KITTITAS COUNTY

MEMORANDUM

TO: All Staff
FROM: Public Works Plan Review Team
DATE: October 5th, 2023
SUBJECT: Public Works Comments: BL-23-00023 M&M Lowe Family LLC

SHEET 1 OF 7

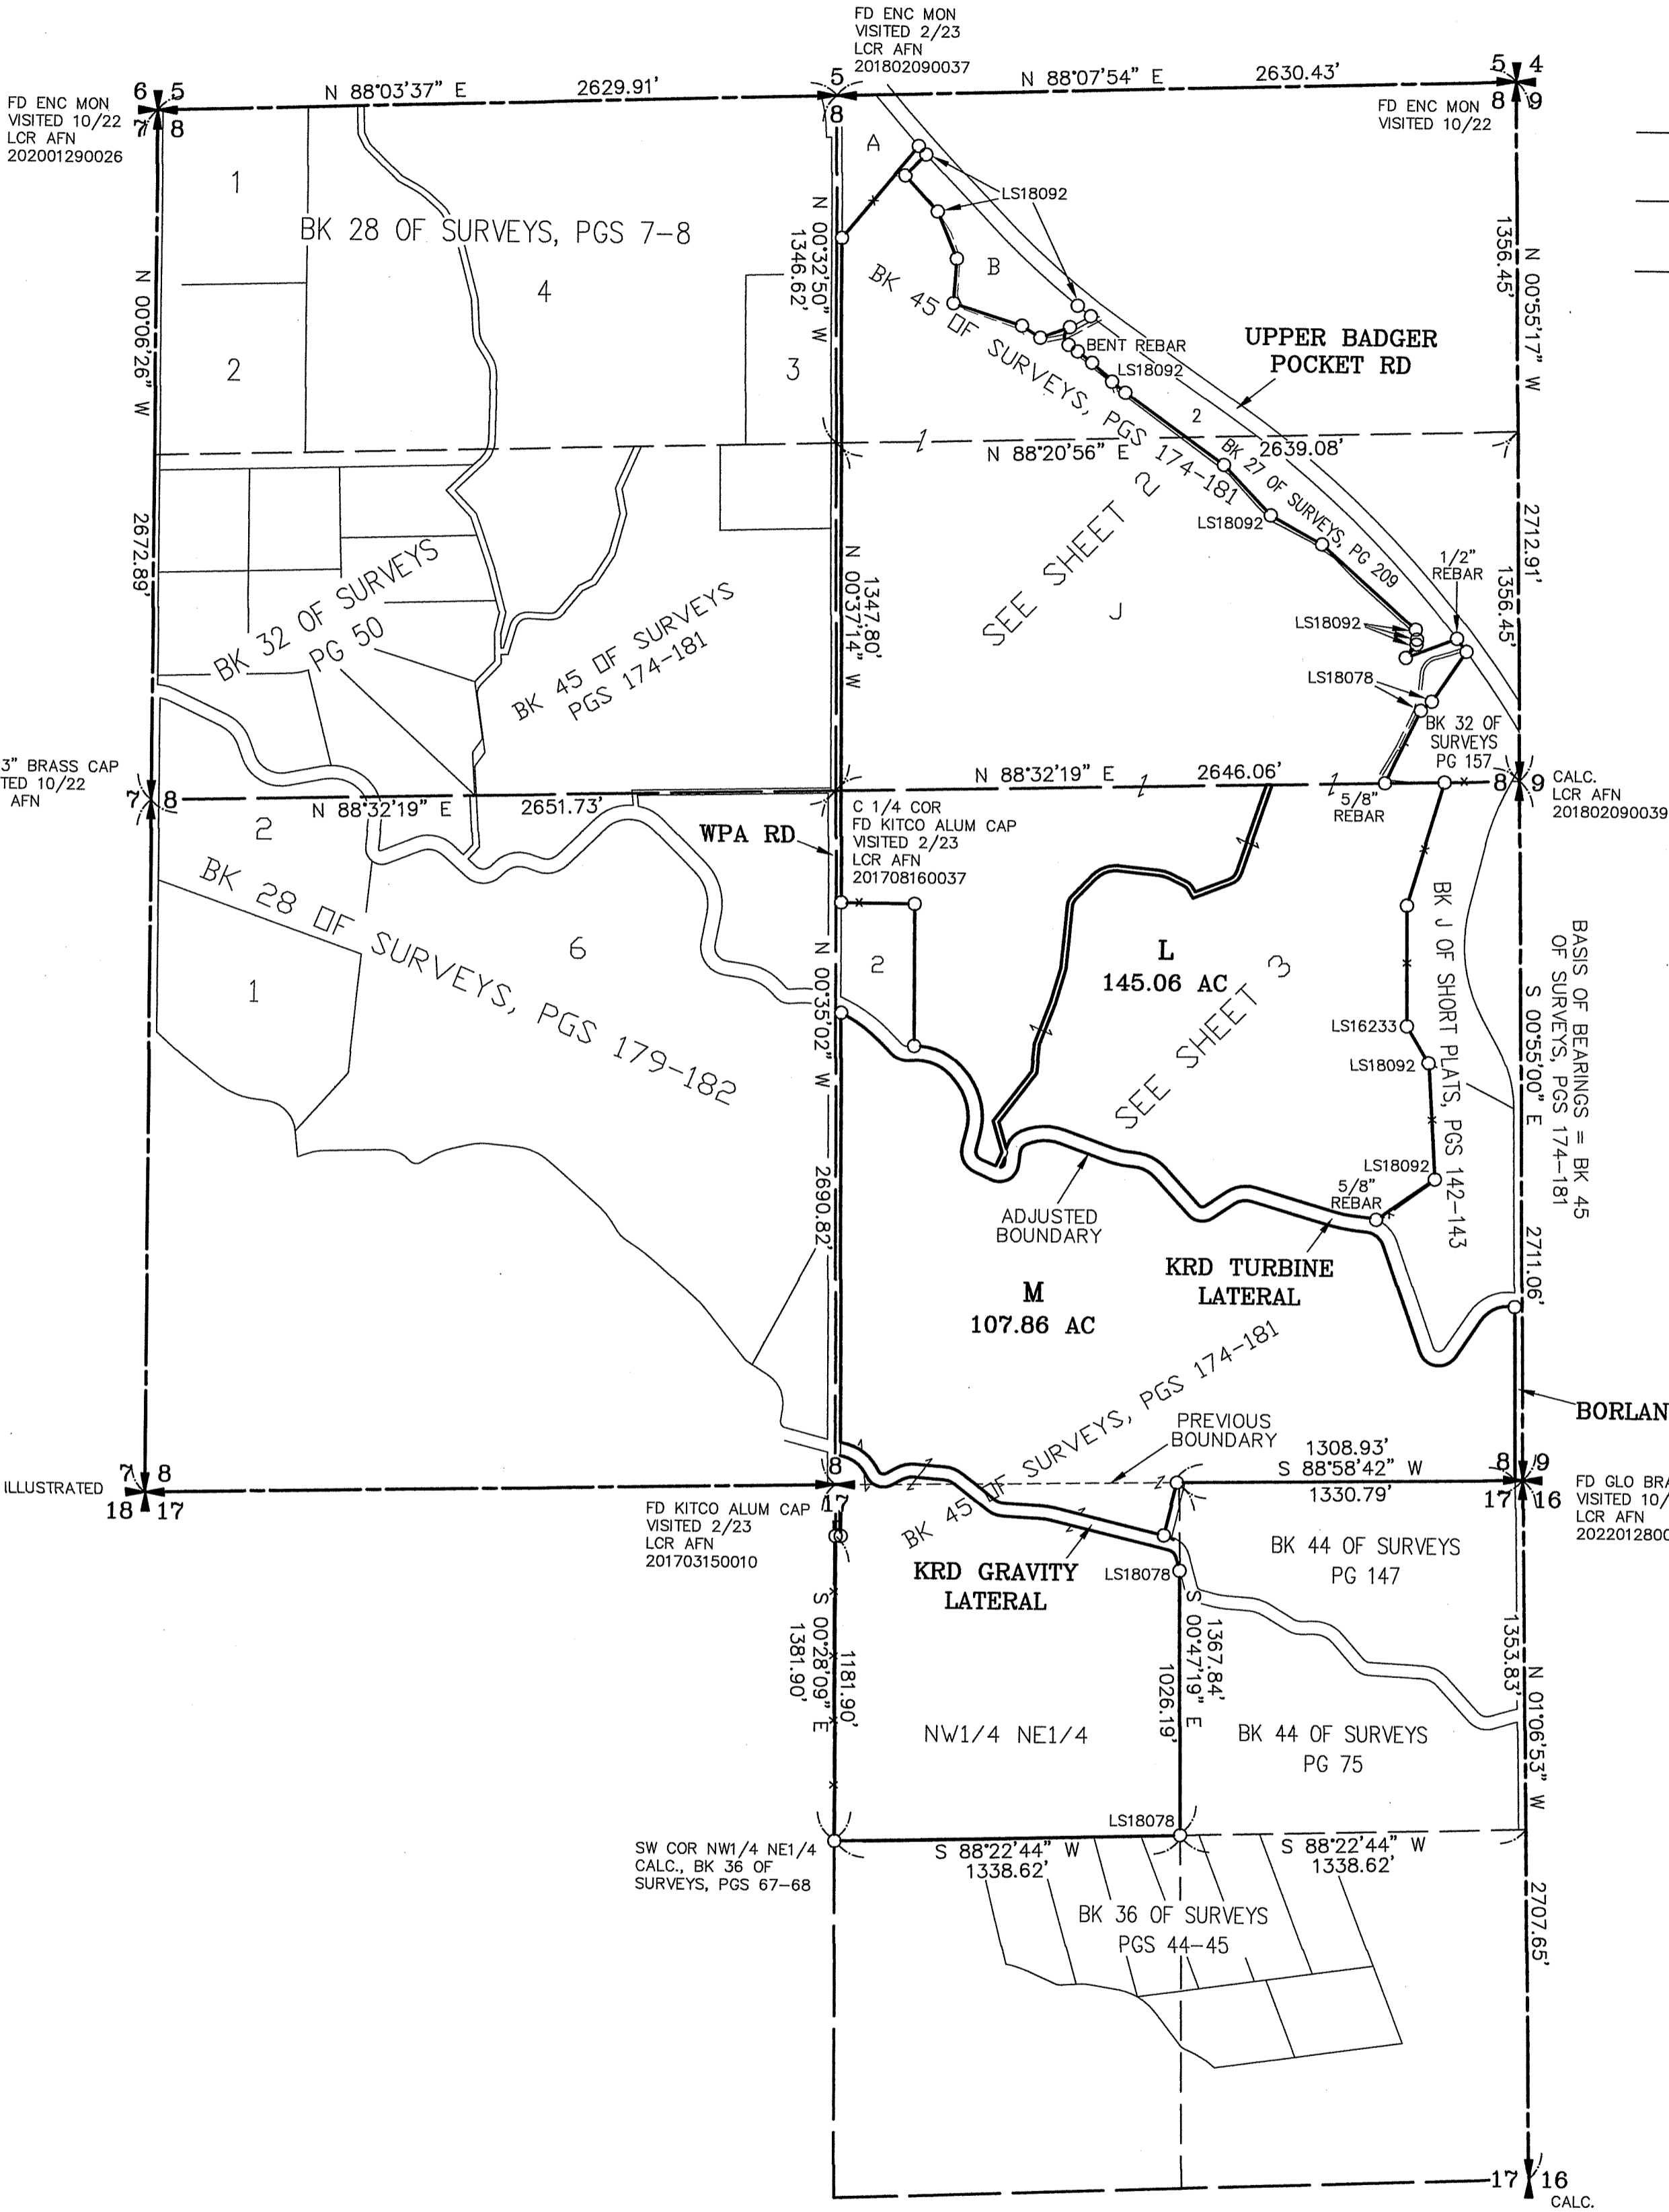
SURVEY	<p>As the application does not contain a survey map, survey reviewed is reserved until final submittal. (JT)</p> <p>UPDATE 11/21/2023</p> <ol style="list-style-type: none"> 1. Please include the R/W width, ownership and surfacing for all roadways. 2. Please show the total distance for the S line of SE1/4 of Section 8. 3. On Sheet 5, Please include the distance along the section line for the E' most portion of Parcel M, in Section 17 N of the lateral (780.56 per the closure rept). 4. Please remove the thin grey line that runs through the legend on Sheet 5. (this may be a result of printing or scanning)

UPDATE 11/29/2023 All prior survey comments have been addressed by the most recent submittal. (JT)
TRANSPORTATION CONCURRENCY	No transportation concurrency application required for this project. (KAH)
FLOOD & WATER MITIGATION/ METERING	No comments. (SC)
